Hornsea Project Three  
Offshore Wind Farm

Applicant Responses to the ExA's First Written Questions

Deadline I: 7th Nov 2018

Figure 3.8: Shortlisted Substation Options.

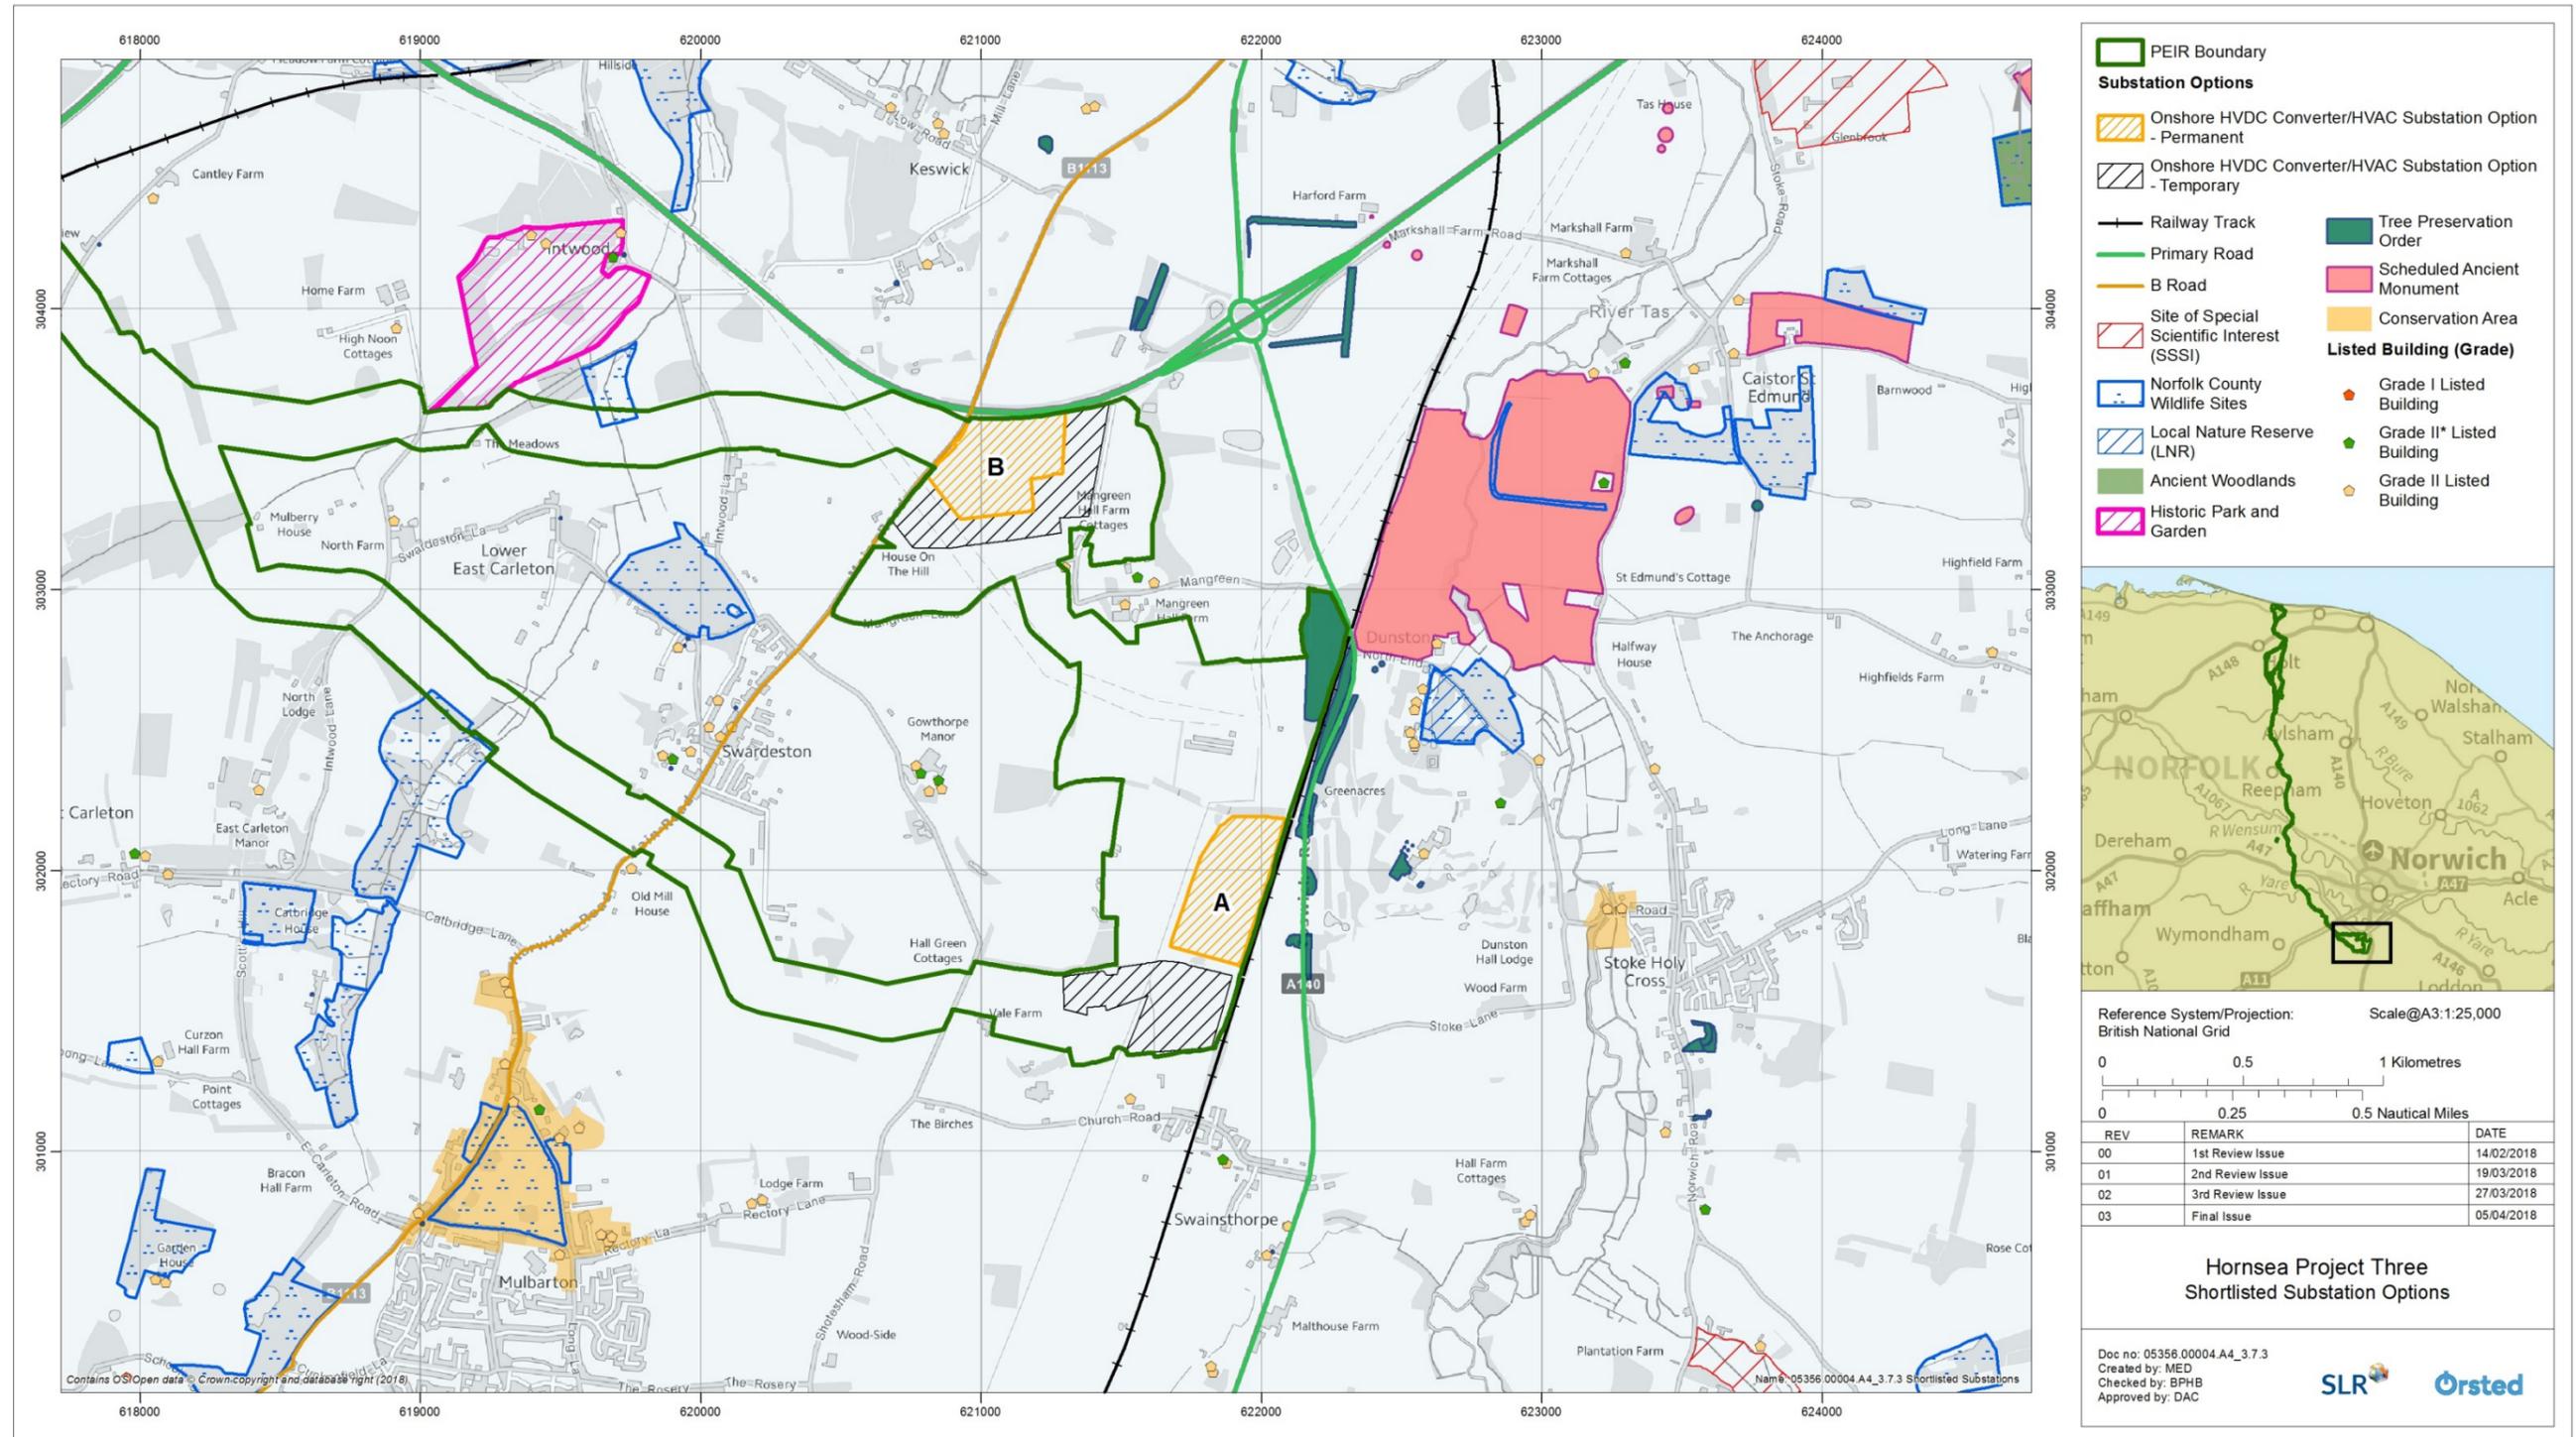
PINS Question number:	Question is addressed to:	Question:	Applicant's Response:
Q1.1.15	Applicant	<p>"Figure 3.8 of the ES [APP-094] shows the shortlisted options for locating the onshore HVDC converter/HVAC substation. The rejected option (Option A) is described as physically more constrained than the selected option.</p> <p>A) What are the relative advantages and disadvantages of the two shortlisted options in terms of landscape and visual impacts and other environmental impacts?</p> <p>B) Please provide further justification for the selection of Option B."</p>	<p>A) In terms of landscape character, both of the shortlisted sites are located within the same landscape character area (B1 Tas Tributary Farmland) as shown on ES Figure 4.3 Sheet 8 (APP-076), with Option B also partly within the adjacent character area (C1 Yare Tributary Farmland with Parkland). As set out within sections 4.11.2.50 to 4.11.2.71 of the ES (APP-076), these two character areas have many similarities and are of the same susceptibility, value and sensitivity.</p> <p>The Option A site is also within approximately 200m of character area A1 Tas Rural River Valley, which is protected by South Norfolk Local Plan Development Management Policies Document (October 2015) Policy DM4.5 as shown on ES Figure 4.1 Sheet 8. ZTV studies for the two options were prepared as part of the viewpoint consultation process and show that whilst the pattern of visibility arising from the two sites is slightly different, the overall area of potential visibility for both options is broadly similar.</p> <p>Option A would have given rise to more extensive visibility from character area A1 – with the potential for effects to arise, whereas Option B indicated limited visibility from area A1 and the river valleys protected by Policy DM4.5.</p> <p>The two ZTV studies indicate that once existing vegetation and built form is taken into account. The Option A site is further from the Norwich View Cones and falls outside of the Norwich Southern Bypass Protection Zone protected by South Norfolk Local Plan Development Management Policies Document (October 2015) Policy DM4.6, as shown on ES Figure 4.1 Sheet 8 (APP-076), and is not adjacent to Undeveloped Approaches as shown on Map 4.6 of the South Norfolk Local Plan Development Management Policies Document 2018.</p> <p>In terms of visual receptors, both sites are near main road and rail routes and are located at similar distances from settlements, though Option A is closer to Public Rights of Way and Option B is closer to local roads.</p> <p>As shown by Figure 3.6 in Annex 4.3: Extracts from Local Landscape Character Area Descriptions to the Environmental Statement (APP-094), proximity to residential properties was considered as part of the site selection</p>

PINS Question number:	Question is addressed to:	Question:	Applicant's Response:
			<p>process and both sites are at a distance such that effects on residential visual amenity would be acceptable, though the Option A site is slightly more distant from the nearest properties.</p> <p>In describing the Option A site as more physically constrained, the appraisal also specifically mentions that Option B has "a greater availability of land for potential mitigation to be implemented" at Annex 4.3 to the ES, para 3.2.4.9 (APP-094).</p> <p>In summary therefore, there is little to choose in landscape and visual terms between the two locations. Option B is likely to have less effects on river landscape character areas protected by Policy DM4.5, but slightly greater effects on some visual receptors (views from roads and residential receptors) but lesser effects on users of Public Rights of Way. However, the reduced constraints affecting Option B were judged to allow more flexibility for the inclusion of effective mitigation, such as landscaping, rather than mitigation options being limited by site constraints.</p>

PINS Question number:	Question is addressed to:	Question:	Applicant's Response:
			<p>B) Section 4.11.5 of APP-059 documents the refinement of the onshore HVDC converter/HVAC substation. It notes that the two substation site options were considered, relative to one another, to determine a preferred option, supported by site visits in the summer of 2016.</p> <p>During the site inspections, further consideration was given to matters such as topography, access, landscape framework/screening, hydrology and ground conditions, to supplement the desk top work that was carried out. Furthermore, the sites had been subject of desk top heritage assessment and phase 1 ecology surveys (as part of the early EIA process) since their initial identification and shortlisting, and this information was also considered.</p> <p>In addition, an assessment of the potential access to Option B identified that this was significantly less constrained and would involve less highway works and the associated construction disruption.</p> <p>Option B also had a receptive landowner, subject to agreement to suitable commercial terms, with Option A presenting a stronger, initial opposition to the citing of the substation on their land.</p> <p>It was determined that Option B provided a greater availability of land for potential mitigation to be implemented. Option A was comparatively constrained by the railway line directly to the east and by the Norwich Main NGET substation to the north.</p>

Figure 3.21 Construction Compound Options.

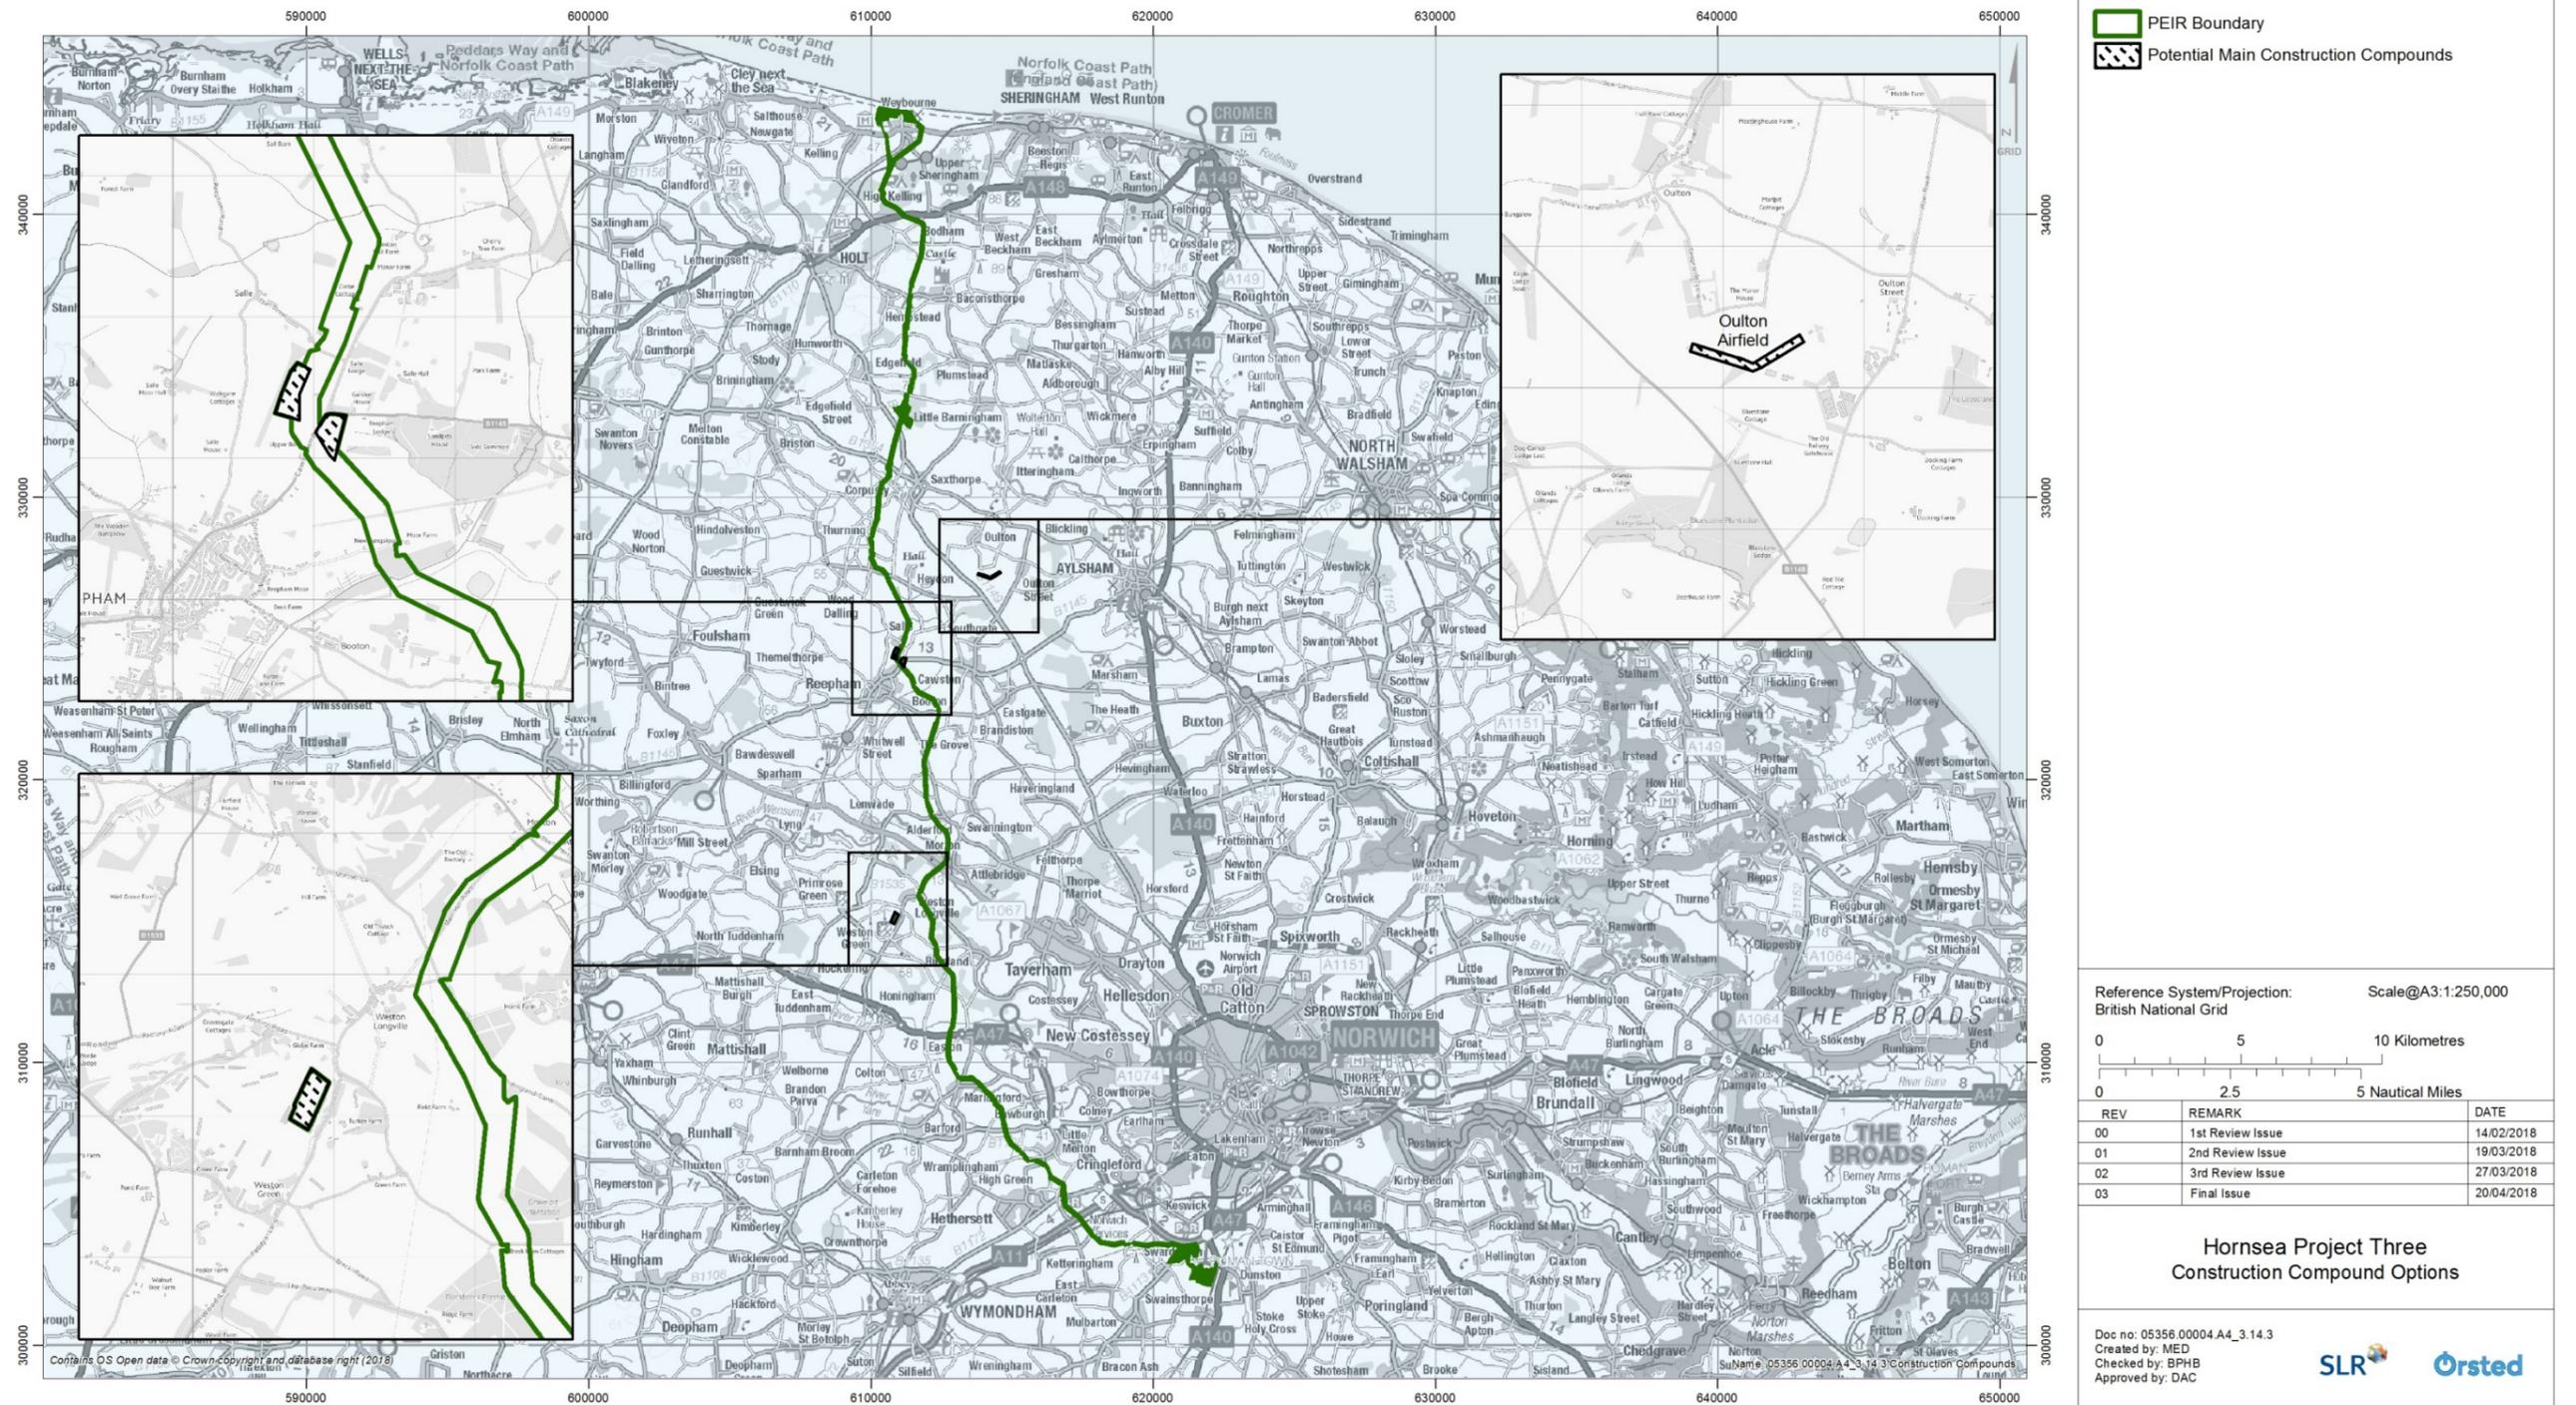
PINS Question number:	Question is addressed to:	Question:	Applicant's Response:
Q1.1.13	Applicant	<p>"Figure 3.21 of Annex 4.3 to the ES [APP-094] indicates the construction compound options that were considered.</p> <p>Please provide further justification for the selection of Oulton Street as the proposed location for the main construction compound."</p>	<p>Justification for the selection of the former Oulton Airfield as the main construction compound is provided at Appendix 20 Main Construction Compound Briefing Note to the Applicant's response to Deadline 1.</p>
Q1.1.14	Applicant	<p>"Mulbarton Parish Council [RR-049] suggests that the Lafarge Aggregates quarry at Mangreen should have been considered as an option for the onshore HVDC converter/HVAC substation.</p> <p>To what extent was the quarry site considered and, if it was considered, what were the reasons for rejecting it?"</p>	<p>Please refer to the Applicants response to Relevant Representation RR-049.</p>
